Our Ref: LU/136/14/HH
Your Ref:

Application for Planning Permission for Works or Extension to a Dwelling

Development New drop kerb & vehicular access. This application may be determined by Littlehampton Town Council under delegated powers

Location 34 Wick Street Littlehampton

Ref 2

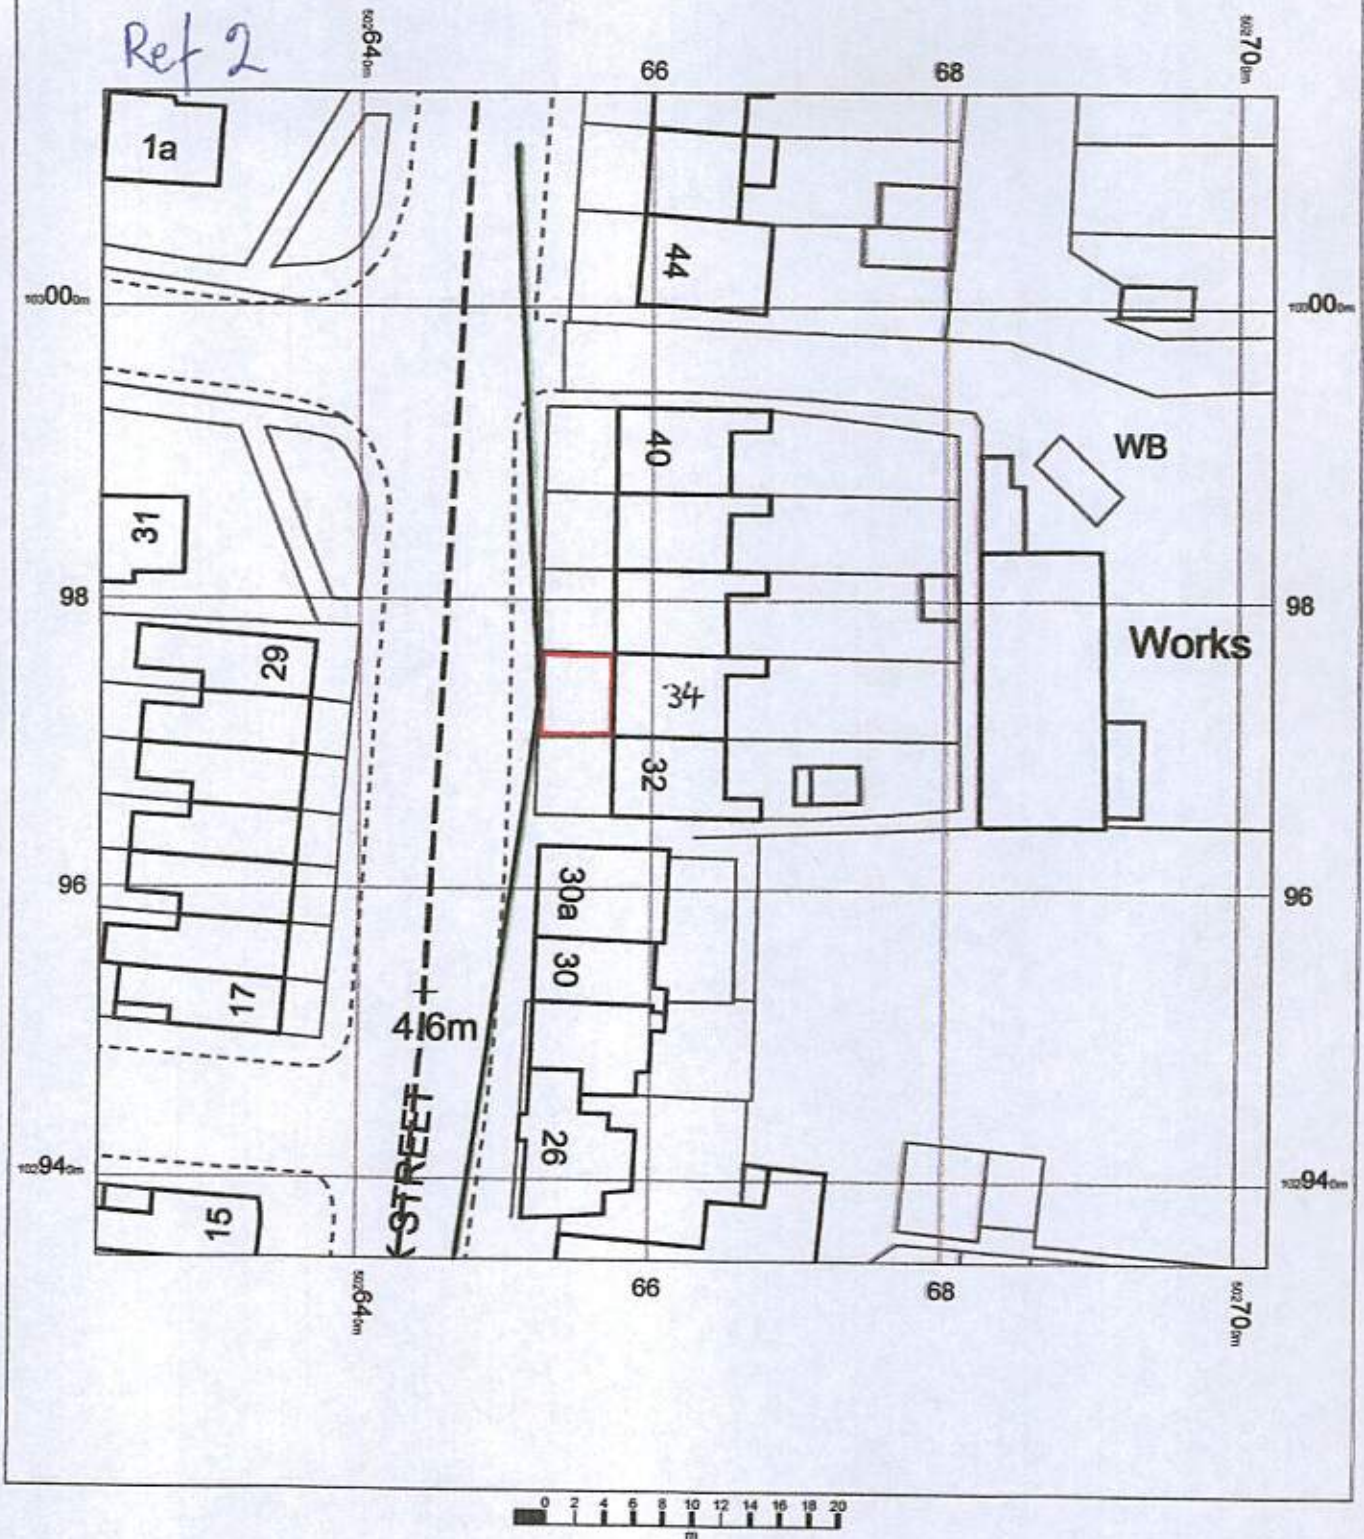
Location Plan

Please submit 1 electronic or 3 paper copies of a revised location plan at a scale of 1:1250 or 1:2500 for rural areas to include the crossover within the red edge. Further details of what must be included on the plan can be found in the National Validation Requirements.
